## REQUEST

Current Zoning: MUDD-O (mixed-use development-optional)  
Proposed Zoning: MUDD-O SPA (mixed-use development-optional, site plan amendment)

Approximately 1.23 acres located in the northeast quadrant of the intersection of Central Avenue and Morningside Drive, south of Roland Street.

The petition proposes to amend a previously approved plan permitting 44,000 square feet of nonresidential uses (with an allowed maximum of 24,000 square feet of retail and EDEE type uses) to increase total square footage to 45,000 square feet and allow residential as a permitted use.

RZP # 2022-224  
OFFICE AND RETAIL  
CENTRAL AVENUE AND MORNINGSIDE DRIVE  
2609 CENTRAL AVENUE

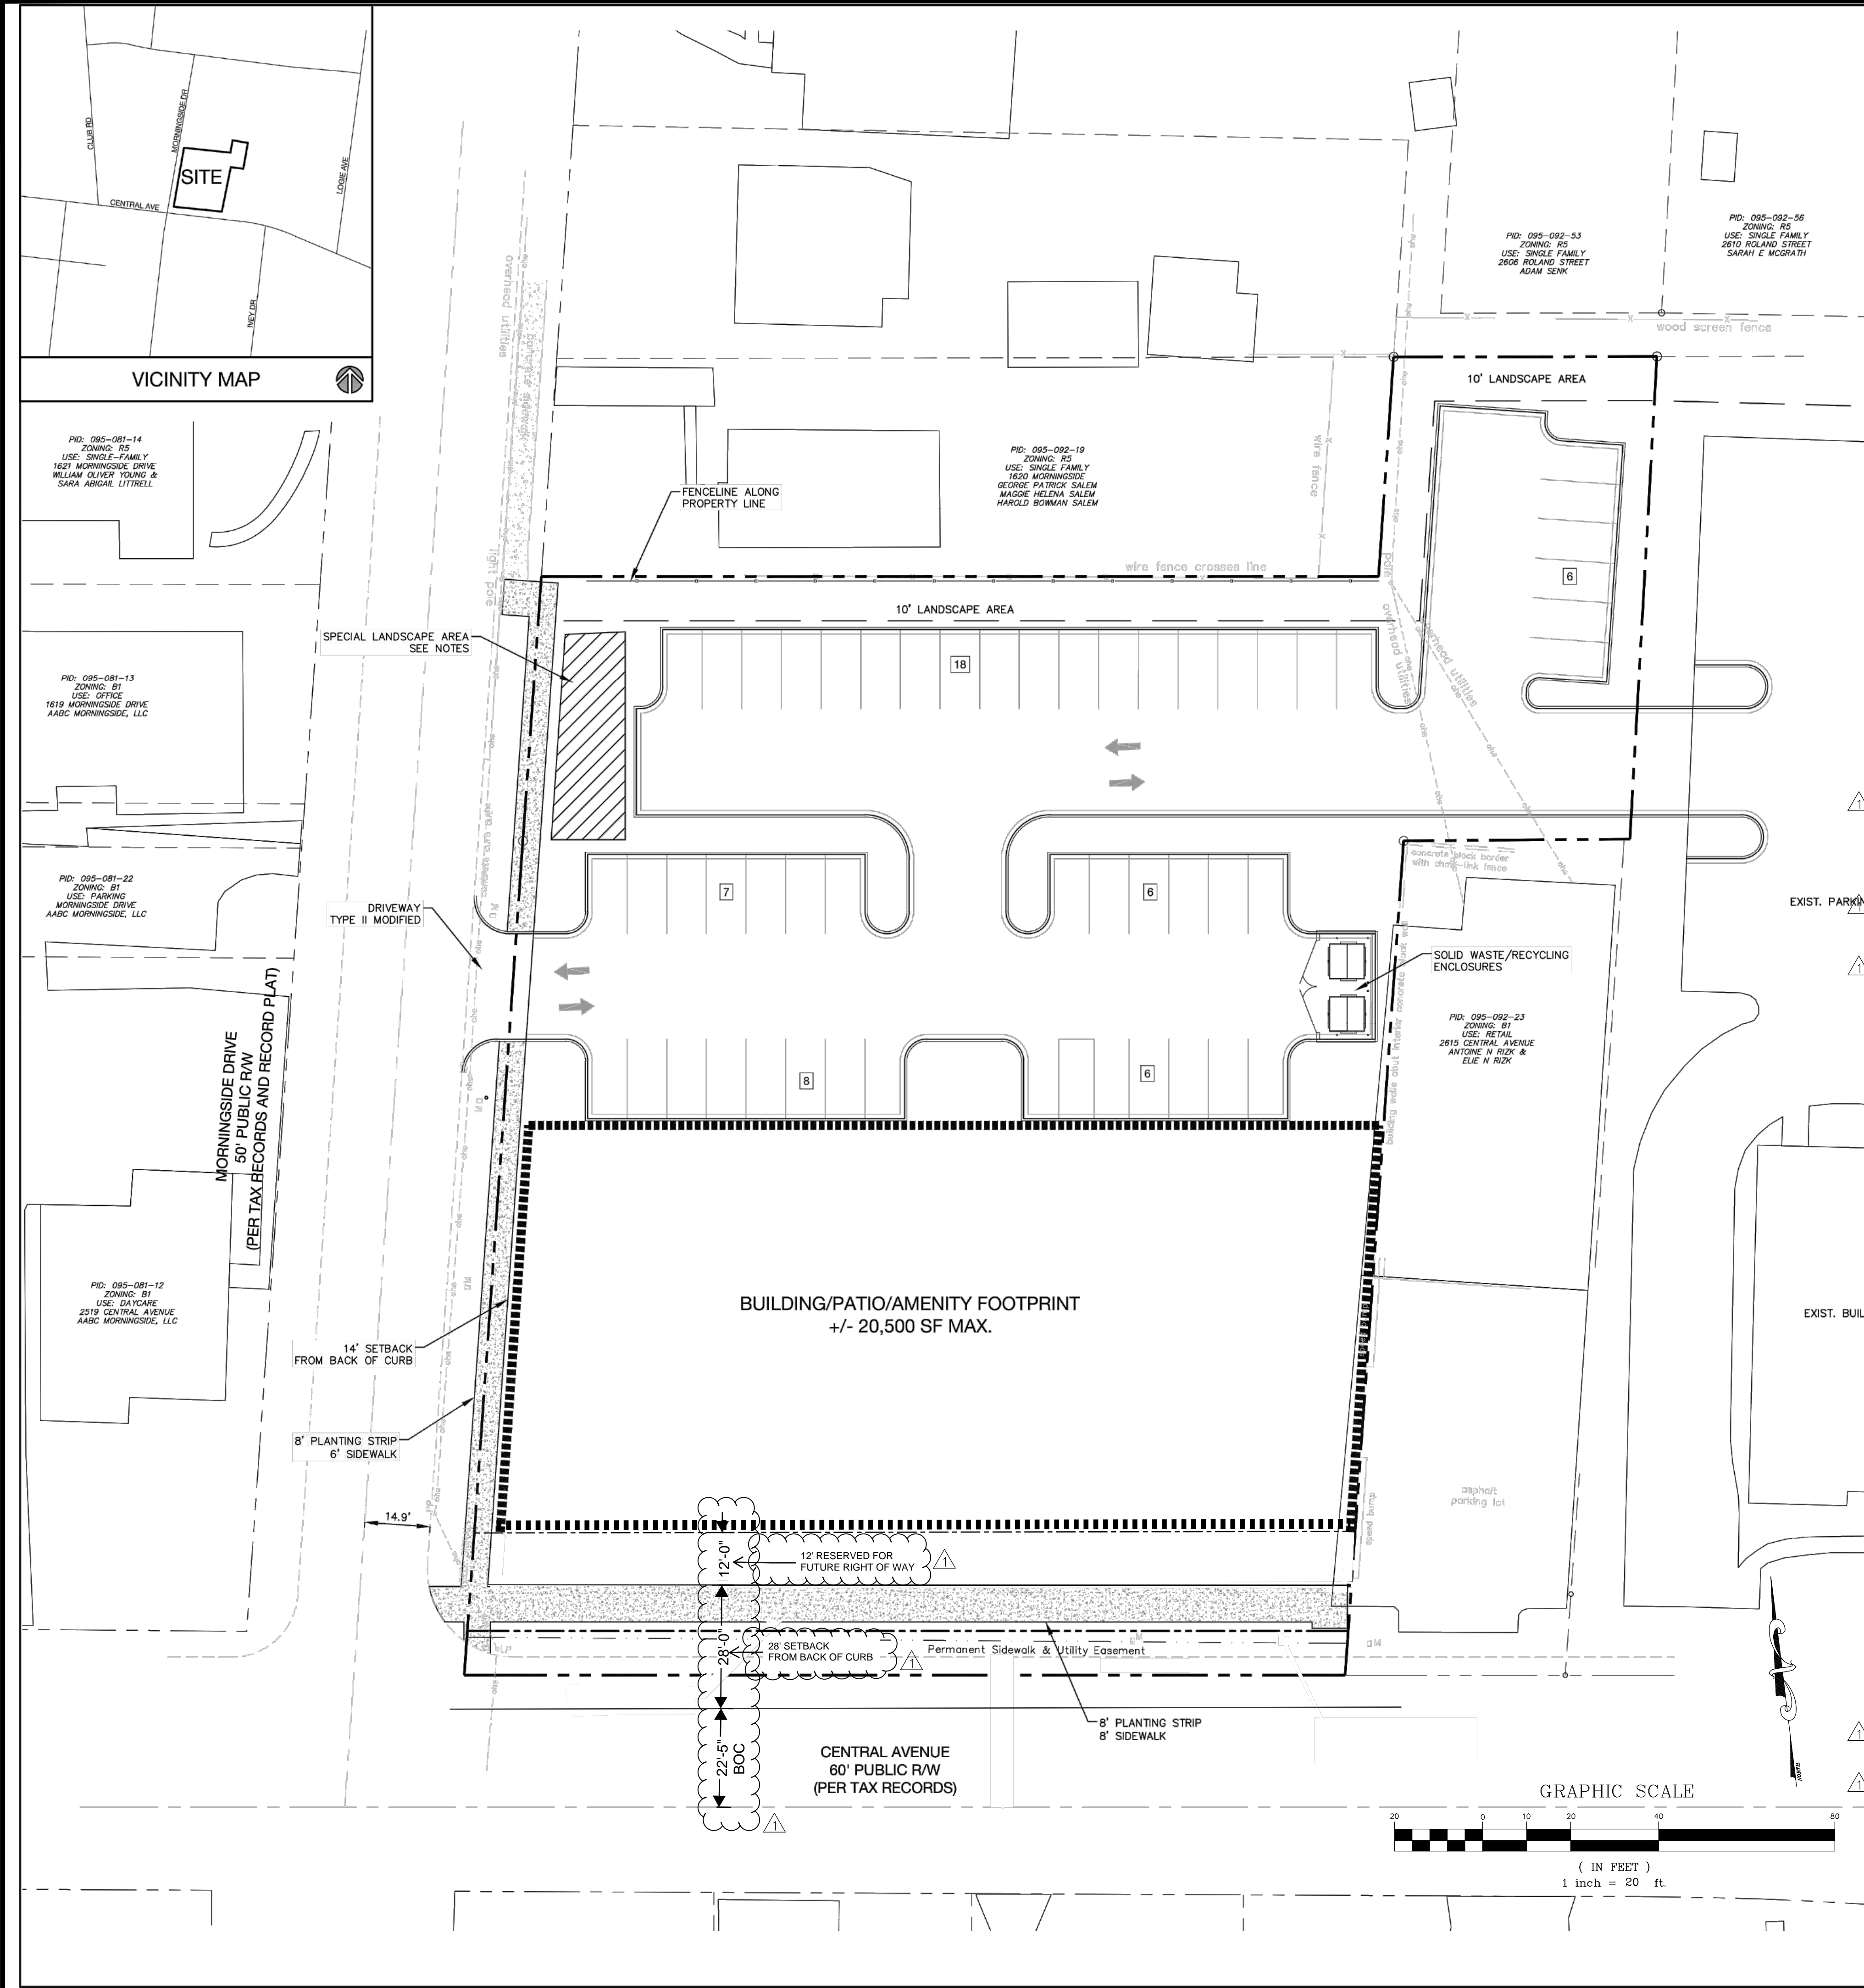
2. Curblines:
  - a. Central Avenue: Location of curb and gutter to be moved to 32.5 feet from roadway centerline to accommodate the Charlotte Streets Map with a roadway typical section of 4 Avenue with Buffered/Separated Bike Lanes.
  - b. Morningside Drive: The future location of curb and gutter is in its existing location.  
NOTE: Additional distance from center line to back of curb may be required in locations where a median is present or around intersections and interchanges.

Label and dimension the curb and gutter from the centerline for each road on the site plan.

3. Revise site plan and conditional note(s) to commit to dedicate 50.5 feet of right-of-way from the Central Avenue road centerline. The site plan shall label and dimension the right-of-way from the road centerline. Comment 11-27-23: Please add a label and dimension showing right-of-way dimension mentioned above on site plan and revise conditional note(s) to commit to previously mentioned right-of-way dimension.
4. Add a conditional note specifying "the Petitioner shall dedicate and convey in fee simple all rights-of-way to the City before the site's first building certificate of occupancy is issued. CDOT requests rights-of-way set at 2' behind back of sidewalk where feasible."

5. Modify optional provisions C and D to ensure expansions are limited to no more than 1,000-1,500 square feet.
